**SSD\_7081: DEVELOPMENT FOR FACULTY OF ARTS & SOCIAL SCIENCES (FASS), CAMPERDOWN CAMPUS**  
**UNIVERSITY OF SYDNEY RESPONSE TO SUBMISSIONS**

**OCTOBER 2016**

The University of Sydney has reviewed all submissions received during the statutory public exhibition period of State Significant Application SSD 7081 – *Faculty of Arts & Social Sciences building*, located on the northern edge of the University's Camperdown campus fronting Parramatta Road, south of campus Science Road, and east of the University's Ross Street entrance.

Extent of the Roof light above the CIP envelop.

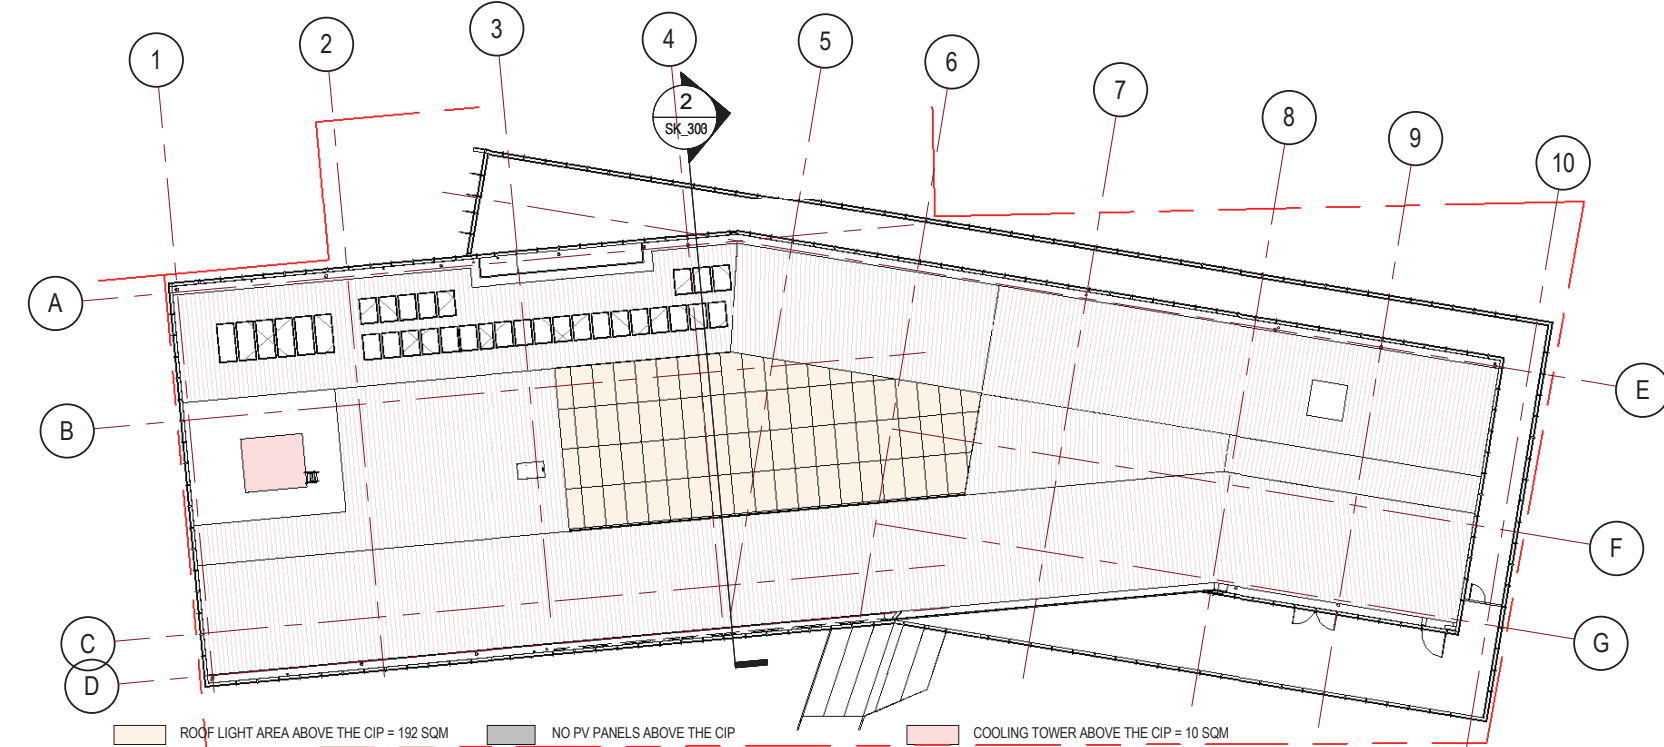
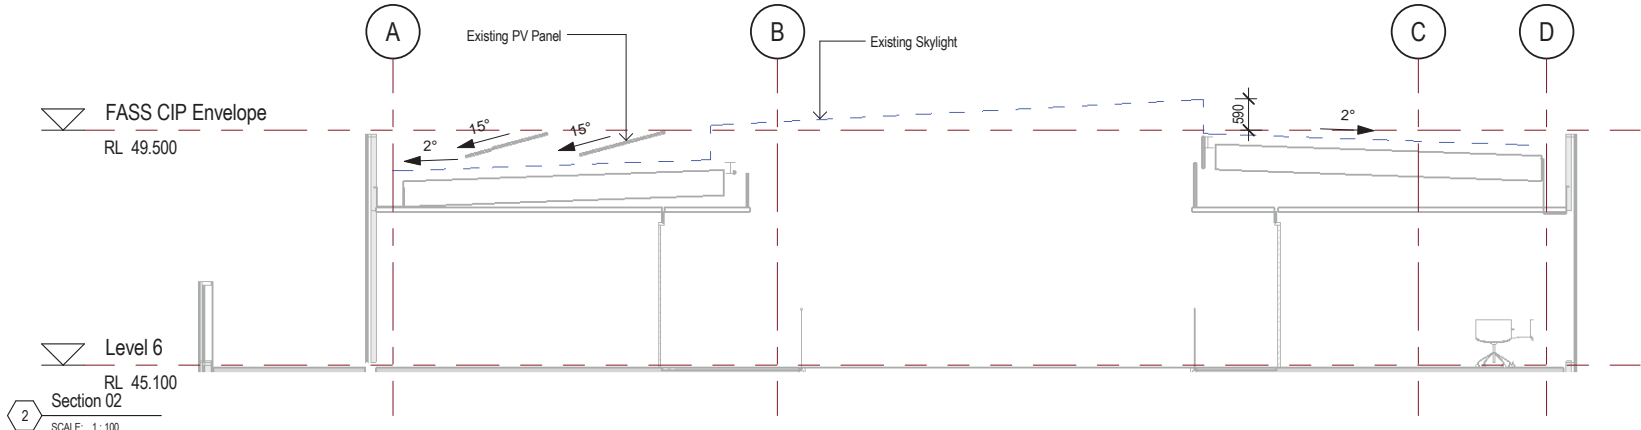
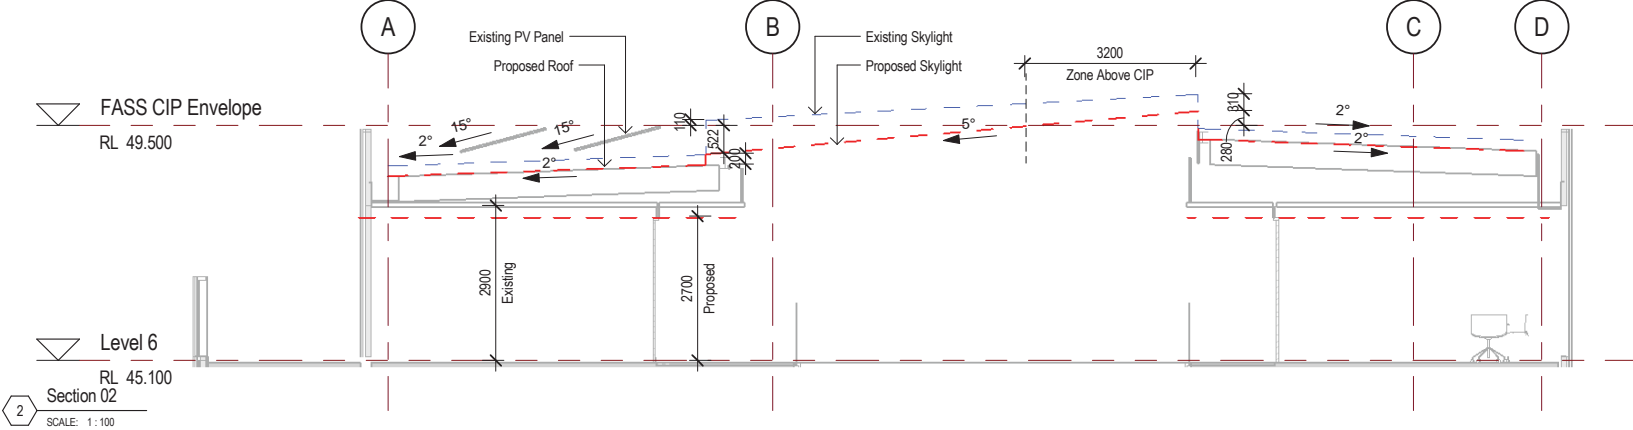
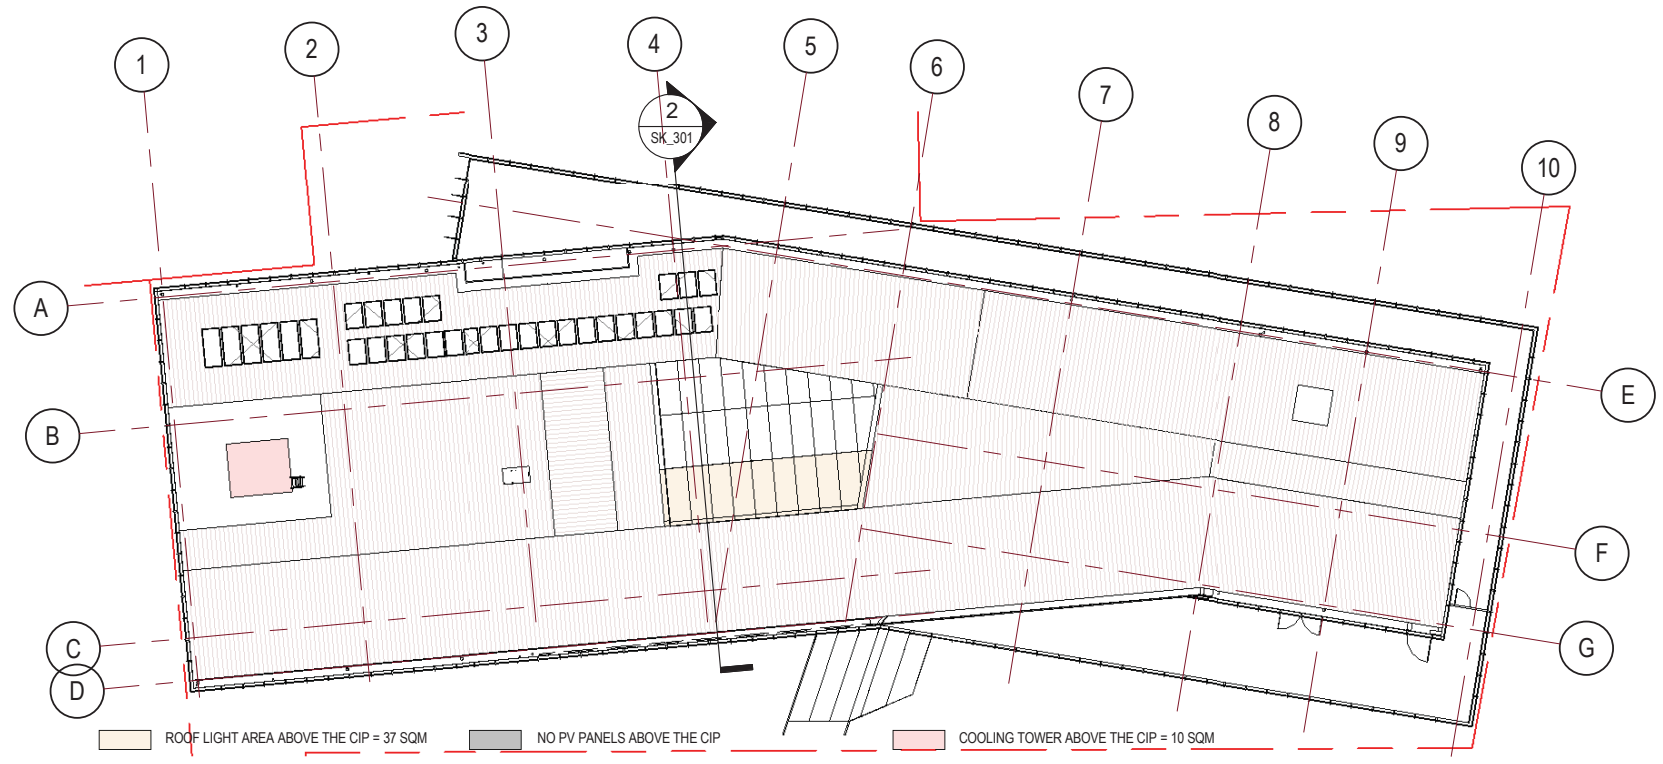
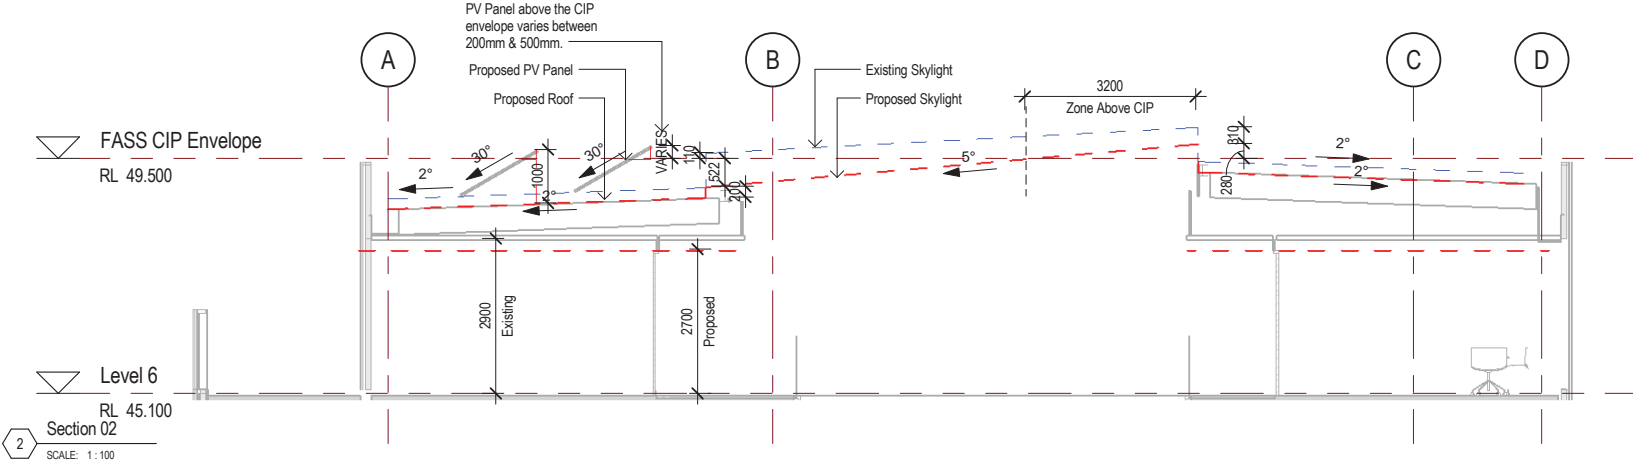
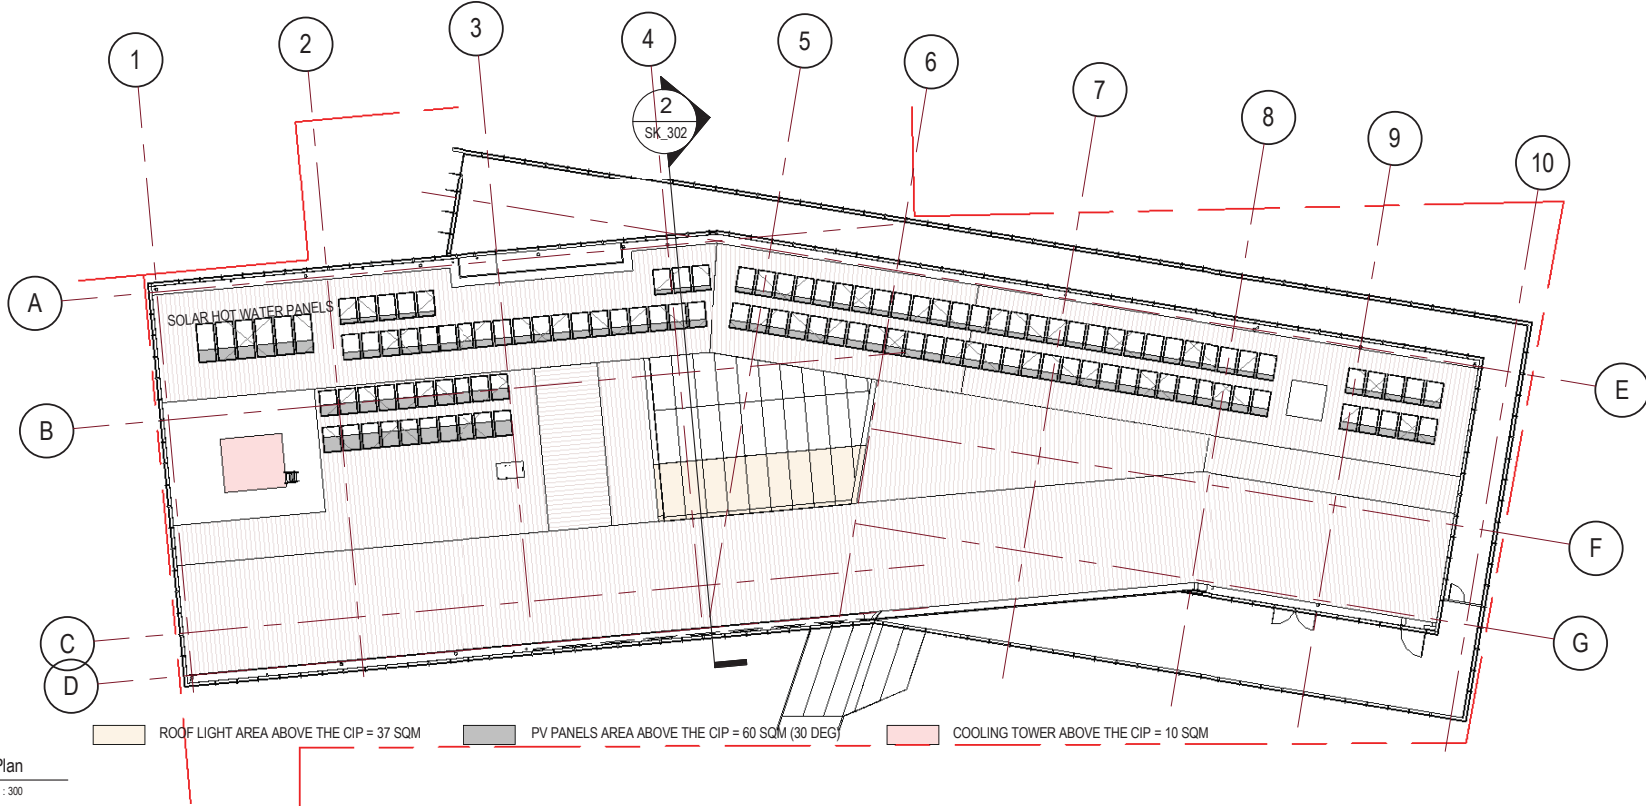
SSD 7081 – FASS BUILDING	
DPE ISSUE	USYD PROJECT RESPONSE
<p><b>Built Form &amp; Urban Design</b></p> <p>1. Given the significant excavation proposed across the site, the Department questions why it is not possible to have designed a building that is fully compliant with the height limit established by the approved CIP building envelope. In this regard, further design refinement should be considered to reduce the height of the proposed building (including plant) to fit within the endorsed RL49.50 CIP envelope height.</p>	<p>As further detailed below, the ground level of the FASS building remains fixed and cannot be lowered or excavated as a result of consequential potential flooding as well as accessibility difficulties.</p> <p>The University has reviewed the FASS building heights against the approved CIP building envelope for this site. The University has now introduced further height reductions to the building comprising:</p> <ul style="list-style-type: none"> <li>Reduction in the level 6 ceiling height to lower the overall roof level by 320mm. This has resulted in reducing the skylight projection through the CIP envelope from 600mm to 280mm.</li> <li>Reduction in skylight area above the CIP from 192m<sup>2</sup> to 37m<sup>2</sup>.</li> </ul> <p>However, the following three elements will protrude above the CIP building envelope and cannot be further reduced. These protrusions are minor, will not cause any negative environmental impact and will not be visible anywhere from the surrounding public domain.</p> <ul style="list-style-type: none"> <li>10m<sup>2</sup> Cooling Tower extending 600mm above the CIP envelope.</li> <li>37m<sup>2</sup> of skylight extending 280mm above the CIP envelope.</li> <li>60m<sup>2</sup> of PV panel area extending 242mm above CIP envelope.</li> </ul> <p>Note, the addition of extra PV panels is in direct response to a recommendation by the City of Sydney.</p> <p>Refer to image below and SK307 illustrating in white colour the minor extent of PV panel, skylight and cooling tower area protruding above the roof area and the CIP building envelope.</p>

Justification for these minor protrusions are substantiated by the following reasons and development constraints:

- A minimum floor to ceiling height of 2700mm needs to be provided to levels 3-6 occupied by academic offices.

SSD 7081 – FASS BUILDING	
DPE ISSUE	USYD PROJECT RESPONSE
	<ul style="list-style-type: none"> <li>• The double height lecture theatre is located at the lower ground floor level 1, therefore setting the floor to ceiling heights for Levels 3 to 6 above.</li> <li>• Level 1 has been set above flood level to allow level access from the South East to avoid building flooding issues from Science Road.</li> <li>• The RD Watt Ground level (Level 2) is fixed. This level dictates the RL of level 2 of FASS to ensure an accessible ground level connection between FASS and RD Watt is maintained.</li> <li>• The roof level is now redesigned by reducing Level 6 floor to ceiling heights from 2900 to 2700mm, and reducing the overall level of skylight from 600mm to 280mm above the CIP envelope. The skylight area is also reduced from 192m<sup>2</sup> to 37m<sup>2</sup> and is set back 6.8m from the facade. Refer to the following Architectus Drawings SK302, 307, DA2500</li> <li>• In relation to the cooling tower (projecting 600mm above the CIP envelope) the University prefers to maintain the water cooled chiller in lieu of air cooled due to a number of environmental advantages being; <ul style="list-style-type: none"> <li>➤ Water cooled chillers require 30% less energy input when compared to an air cooled chiller.</li> <li>➤ Water cooled chillers generate less noise than air cooled chillers.</li> <li>➤ Water cooled chillers typically last longer than air cooled chillers – this has certainly been the experience on campus with 25 years typical for water cooled and only 15 years for air cooled chillers – this leads to a reduced embodied energy cost.</li> </ul> </li> <li>• The most compact water cooled chiller has been selected which has specific dimensional requirements that cannot be reduced below the CIP envelope. Therefore the University wishes to retain the water cooled chiller and associated cooling tower plant due to the reduced energy and embodied energy advantages.</li> </ul>

1 East Courtyard Level 02 Plan  
SCALE: 1: 200

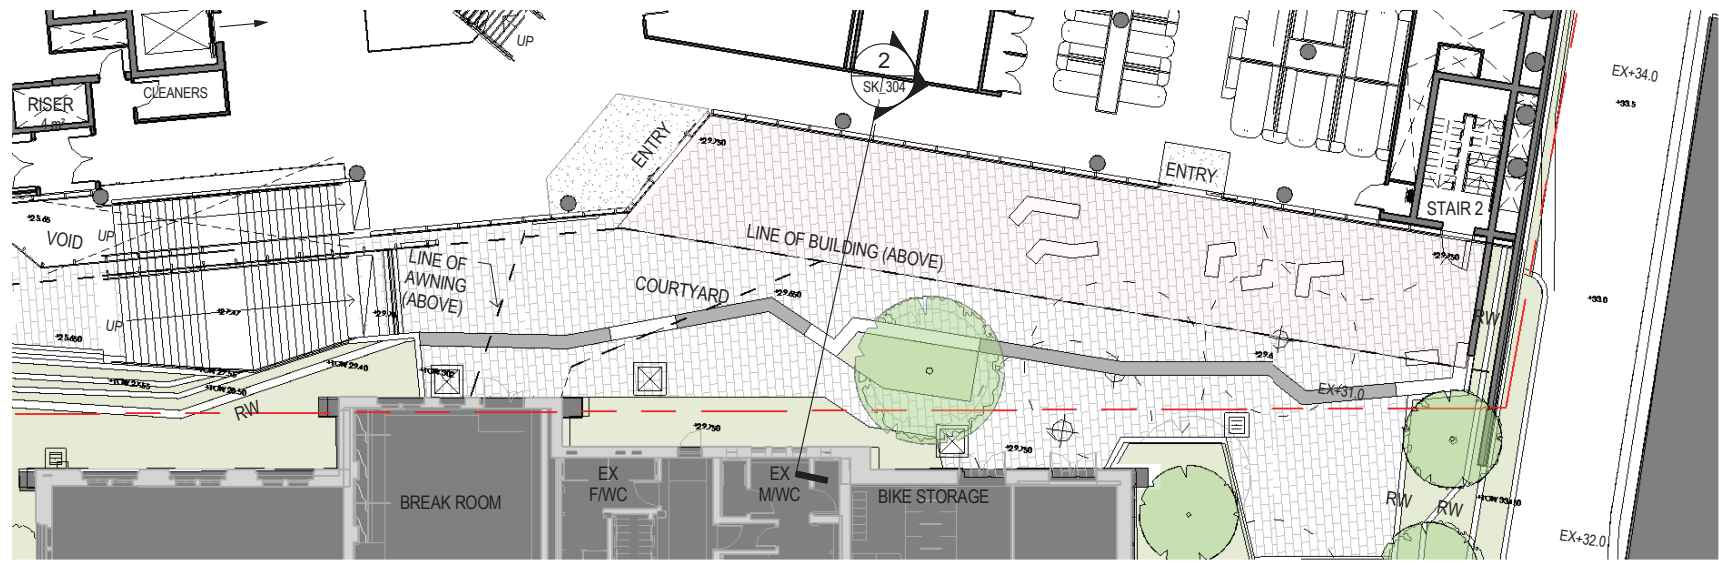
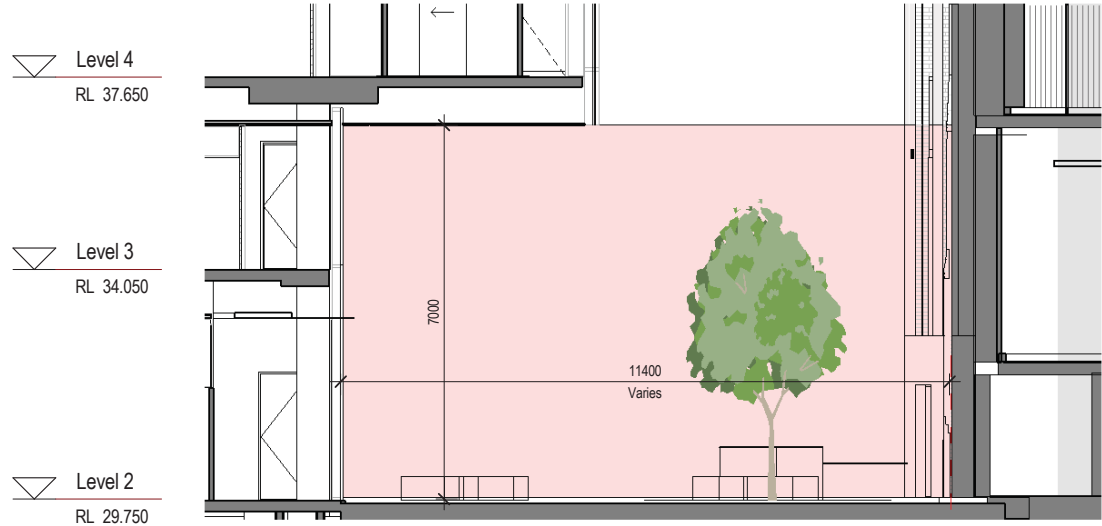
<p>3. Further assessment is to be undertaken regarding the predicted overshadowing and amenity impacts generated in the central courtyard between the new faculty building and existing RD Watt Building, and how the amenity of this space is proposed to be enhanced to encourage throughout the day.</p>	<p><b>Campus Domain Context:</b> In addressing the amenity of the courtyard, it is important to first identify the function of the courtyard between FASS and RD Watt, as well as the adjoining primary campus domain feeder of Science Road.</p> <p>The courtyard between RD Watt and the FASS Building is designed to act primarily as a circulation and entry space to and between both buildings. This is a secondary space to the primary campus domain spine of Science Road which currently serves as both principal pedestrian connections to all buildings fronting Science Road as well as a vehicle feeder for services, emergency vehicles and a variety of small surface parking areas.</p> <p>The CIP Concept Landscape Plan (SSD 13_61123 approved on 16 February 2-015), prepared by Clouston, shows the space between RD Watt and the rear future building site (now proposed as FASS), as a very narrow space principally serving as a connection between buildings and with limited landscape opportunities.</p>

SSD 7081 – FASS BUILDING	
DPE ISSUE	USYD PROJECT RESPONSE
	<p><b>Courtyard Design:</b> Having established that the internal courtyard between FASS and RD Watt serves primarily as a pedestrian connector for specific users and visitors to FASS and RD Watt buildings, the design of the courtyard has been deliberately kept largely open in order to allow the movement of people into both buildings. The courtyard is designed as a spine with 2 components on the south side of the FASS building.</p> <ul style="list-style-type: none"> <li>a) The East courtyard is the principal pedestrian thoroughfare, providing an accessible pedestrian route from Science Road (east) that takes advantage of the higher road topography.</li> <li>b) The West courtyard is a secondary lower and more spatial entry courtyard which also provides controlled periodic maintenance vehicle access. The southern elevation of FASS, which partly frames the courtyard, is setback from Science Road and is not visually prominent from the Science Road streetscape. Due to the significant east-west sloping topography of the site and Science Road, this courtyard is also framed by the RD Watt building, the Lecture Theatre function of lower FASS levels, and by a stair connection to the upper courtyard level.</li> </ul> <p>The façade of the Lecture Theatre also influences the courtyard design and environment. Ongoing design development and feedback with the faculty user groups has confirmed that the original glass façade to the proposed Lecture Theatre will be detrimental to the privacy, study environment and function of the Theatre, and consequentially an enclosed 'private' teaching environment is required. The Theatre is now also required to be used for digital cinema projection, which would not be possible with the glazed façade. Consequently, a solid façade is proposed which also creates an opportunity to integrate an external public artwork piece or interpretational installation to further encourage awareness of Aboriginal values, art and culture.</p>

SSD 7081 – FASS BUILDING	
DPE ISSUE	USYD PROJECT RESPONSE
	<p><b>Courtyard Amenity:</b> The design of the east and west courtyards has been further developed to integrate the heritage landscaping with the Wingara Mura landscape approach to create a socially, culturally, historically and contextually responsive outcome layered with meaning and resonance.</p> <p>In the east courtyard, the planted treatment to R D Watt, which currently exists along the southern and to a lesser extent western sides of the building, have been extended around to the eastern and northern sides to continue the heritage landscape curtilage around RD Watt. Openings in the curtilage allow connections between RD Watt and FASS. The design of the east courtyard references the pre-development landscape of Sydney Sandstone Ridge associated with the former Orphan School Creek with its stone floor materiality, and reference to former tributaries in the expressed meandering drainage grating detail which runs down to the lower west courtyard. A central feature tree and seating have been integrated into the courtyard as a breakout seating area.</p> <p>The East courtyard is designed to mitigate wind issues by integrating an awning connection between the two buildings and providing landscaping to the lower courtyard, as recommended by the Wind Consultant.</p> <p>In conclusion, the setting of R D Watt and the east courtyard amenity as a pedestrian connection has been considerably enhanced by the proposed development.</p> <p>The west courtyard references the pre-development landscape of Sydney Sandstone Gully Forest associated with the former Orphan School Creek with its grove of trees and paving material, extending meaning and memory reference of the site's heritage from the upper courtyard to the lower.</p> <p>Windtech has reviewed the updated landscape design and has determined that with the inclusion of additional landscaping the amenity of the courtyard is considered to be satisfactory.</p>
